From: Andrew Wood <Andrew.Wood@arun.gov.uk>
Sent: 27 May 2020 11:46
To: Planning.Responses <Planning.Responses@arun.gov.uk>
Subject: FW: Planning Consultation on: A/45/19/PL

Engineers Comments Regarding Surface Water Drainage

APPLICATION NO: **A/45/19/PL**

Description of Works: Demolition of existing buildings (car show room, workshops and Phares Courtledge) and erection of 19 dwellings, a convenience store, a community building, public toilets and associated car parking and landscaping - This application affects the character and appearance of the Angmering Conservation Area.

-SURFACE WATER STRATEGY-

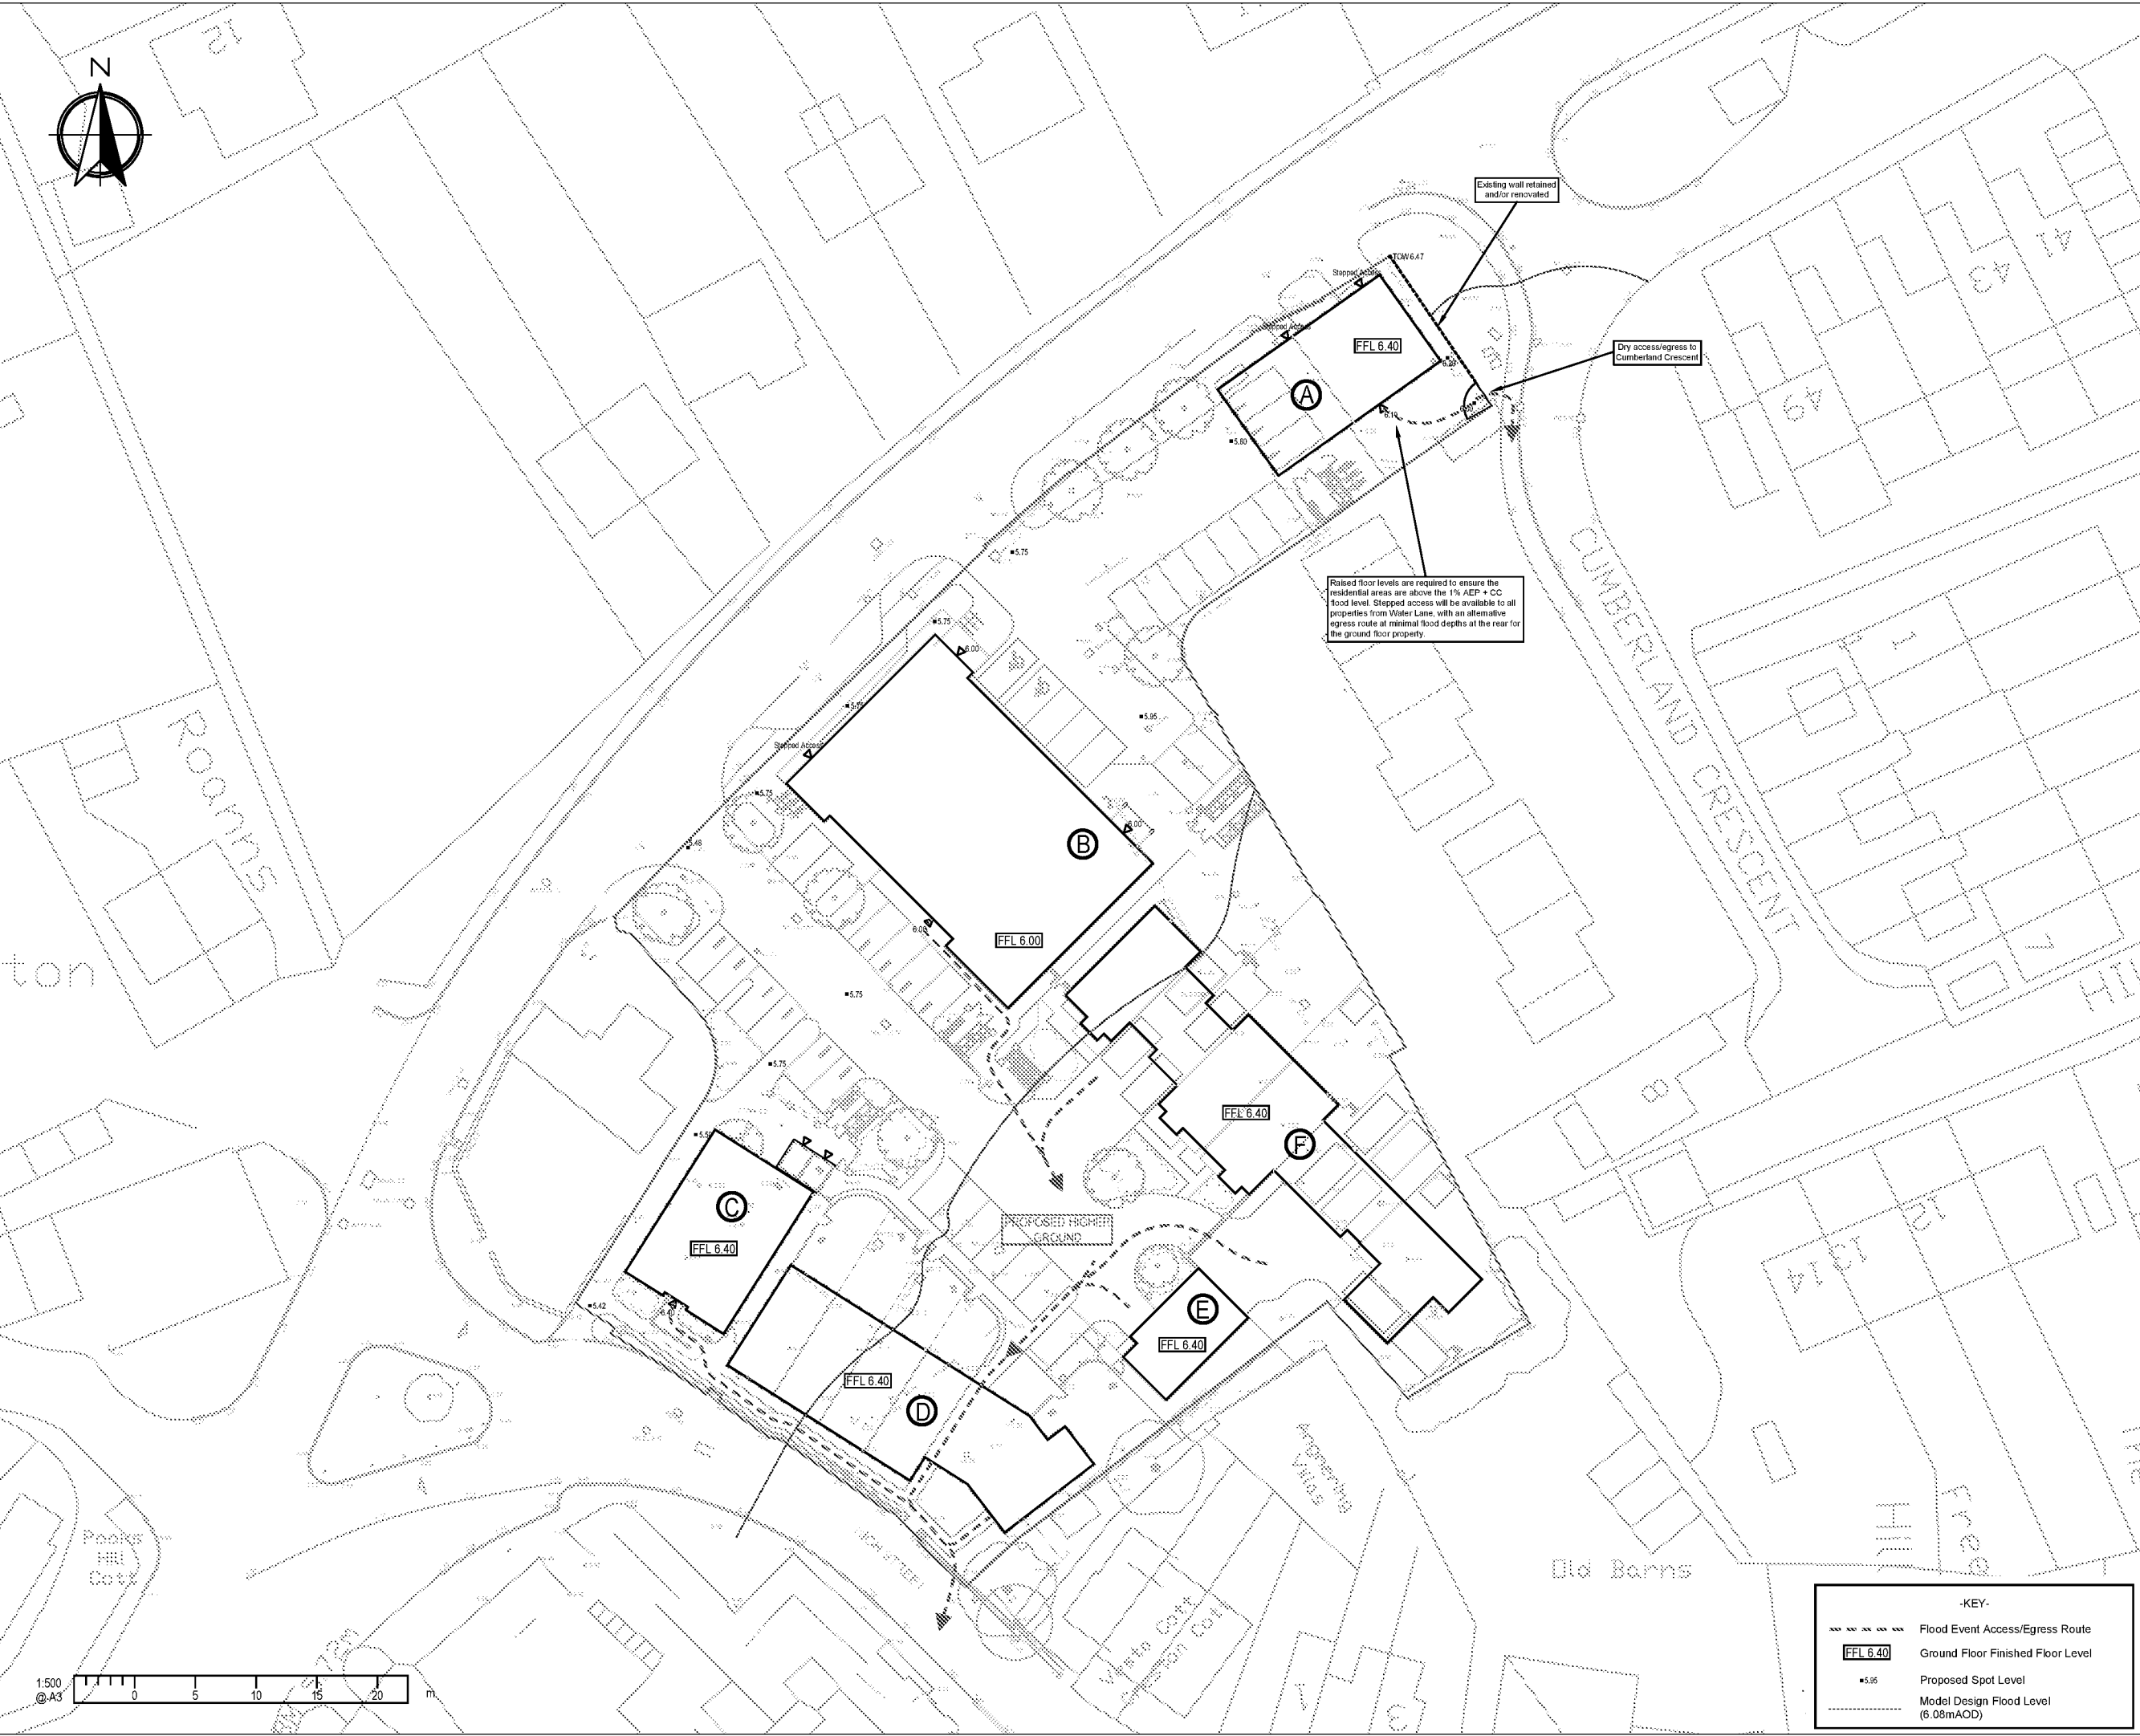
The submitted FRA details that some of the existing drainage arrangement will be utilised. Given the high risk of flooding in the area we would be looking to obtain improvement from the proposals, in line with WSCC policy we require proposed discharge rates to be as close to greenfield QBar as possible. Any proposals to alter or provide additional connections to the culverted main river would require a flood risk activity permit from the Environment Agency.

It is not clear from the detail submitted if the attenuated volume can be contained on site outside of the predicted flood extents. I.e. it has not been demonstrated that the proposals will not increase flood risk and the development can be adequately drained. A layout plan of the proposed surface water drainage scheme needs to be submitted, with further refined calculations. This information needs to be submitted before determination of the application. **Therefore, I currently object to the proposal.** Once further detail has been supplied by the applicant please re-consult.

"Development shall not commence, other than works of site survey and investigation, until full details of the proposed surface water drainage scheme have been submitted to and approved in writing by the Local Planning Authority. The design should follow the hierarchy of preference for different types of surface water drainage disposal systems as set out in Approved Document H of the Building Regulations, and the recommendations of the SuDS Manual produced by CIRIA. Winter groundwater monitoring to establish highest annual ground water levels and winter Percolation testing to BRE 365, or similar approved, will be required to support the design of any infiltration drainage. No building / No part of the extended building shall be occupied until the complete surface water drainage system serving the property has been implemented in accordance with the agreed details and the details so agreed shall be maintained in good working order in perpetuity."
